Application Reference: 2025/1084

Site Address: 1 Eyam Close, Dodworth, Barnsley, S75 3SQ

Introduction: Single storey side extension (Amended Description)

Drawing Title  
**PROPOSED PLANS**

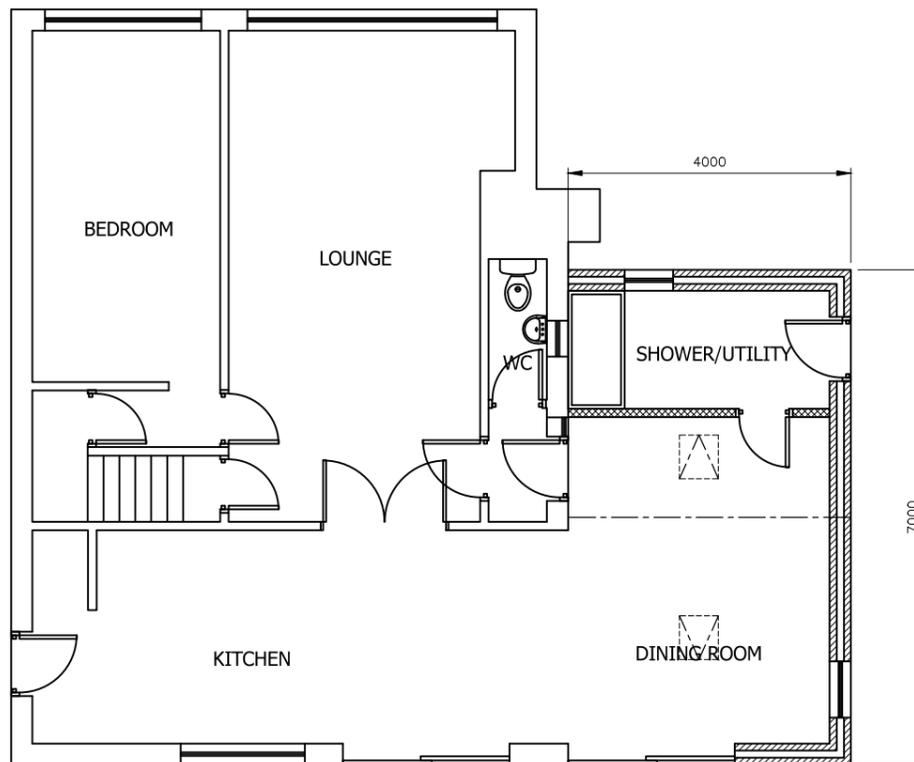
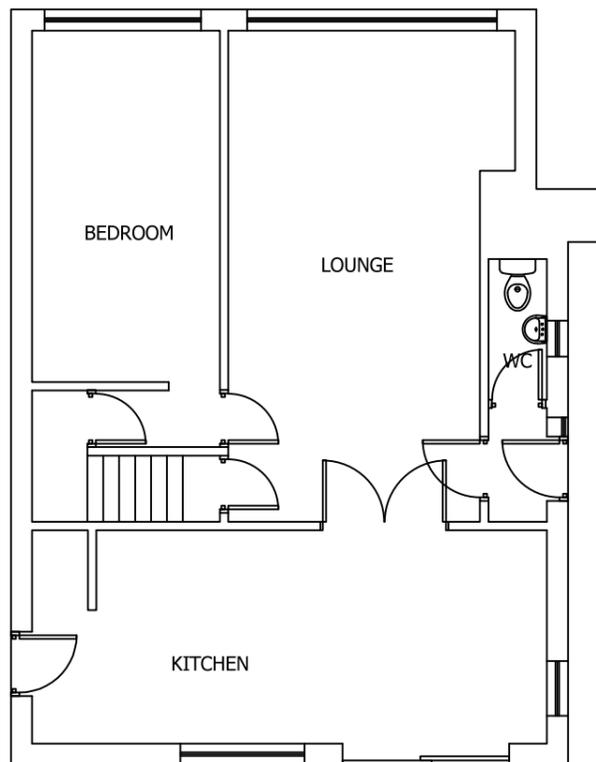
The proposed projection of 4 metres is less than half the width between the dwelling and the boundary and is less than two thirds the width of the dwelling. The projection is therefore acceptable when assessed against the house extension SPD. A pitched roof is proposed which allows the proposal to remain in keeping with the character of the dwelling and surrounding area. The proposed glazing is similar to other fenestration on the dwelling.

The proposed extension would not be impactful on neighbours to the south. The extension is single storey and would therefore have little impact in terms of overdominance. The extension is substantially screened by boundary treatment and the proposal is distanced by highways preventing any loss of neighbouring outlook. The extension provides glazing to the south elevation, however given the proposal is single storey and substantial screening is in place, there is little opportunity for overlooking. The glazing to service the proposed shower/utility room shall be conditioned to be obscured glazing in order to protect the privacy of both the applicant and neighbours. Additionally any glazing which would be installed on the shower/utility room door shall also be conditioned to be obscured glazing for the same reasons set out above.

Drawing Title **PROPOSED ELEVATIONS**

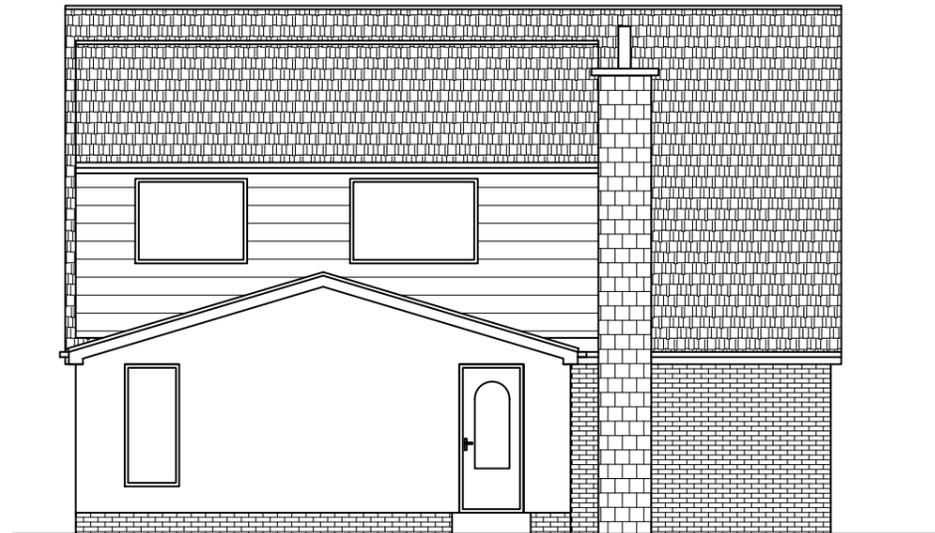
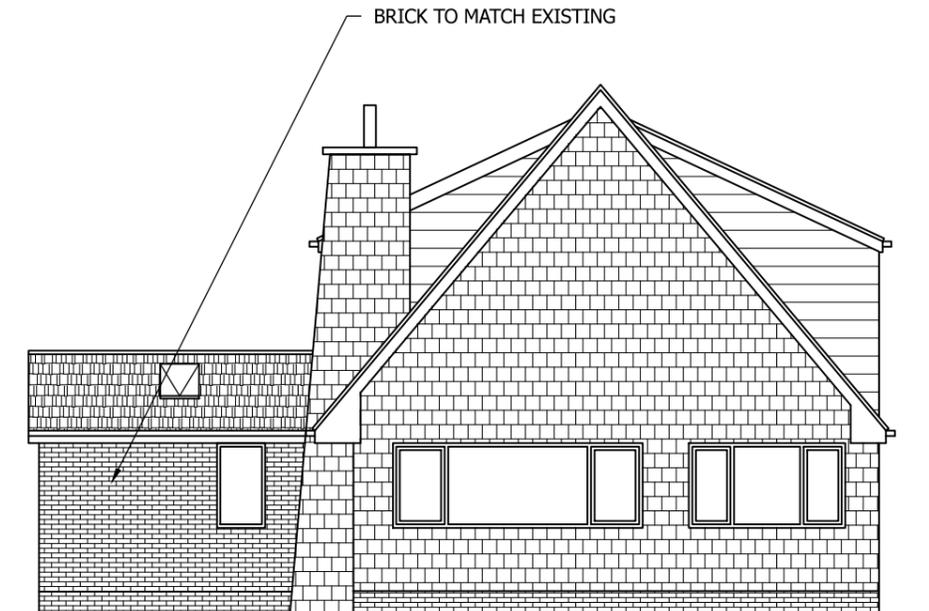
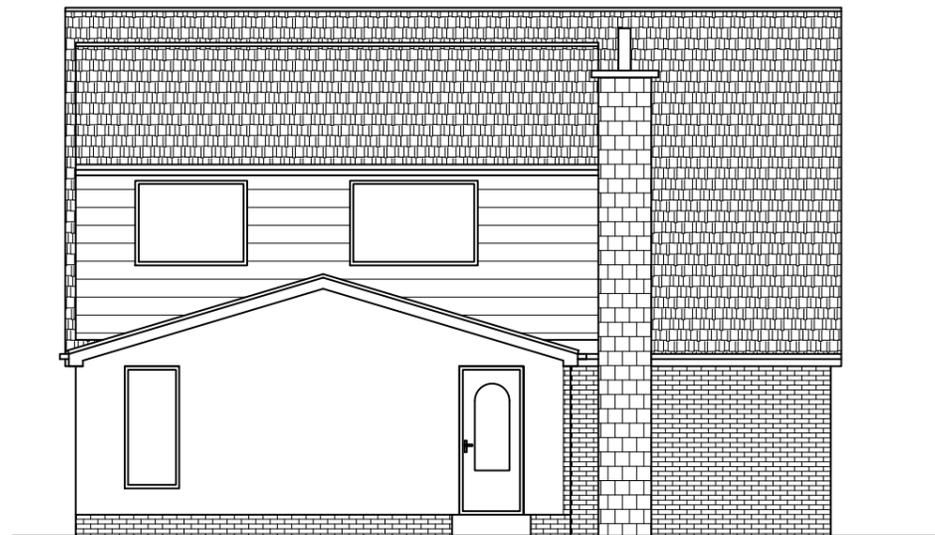
Matching brickwork has been detailed to the front elevation, which allows the proposal to remain in keeping with the character of the dwelling. White render has been proposed to the side and rear elevation. Given the extension is single storey and is substantially screened to both the rear and the side, the render would not be seen within the street scene and therefore would not be impactful on the character of the street scene.

It has been necessary to make contact with the applicant to amend the plans to allow for matching brickwork to be maintained to the rear elevation and for the front elevation of the

extension to be constructed from matching brickwork. Amendments were received 26th January 2026.
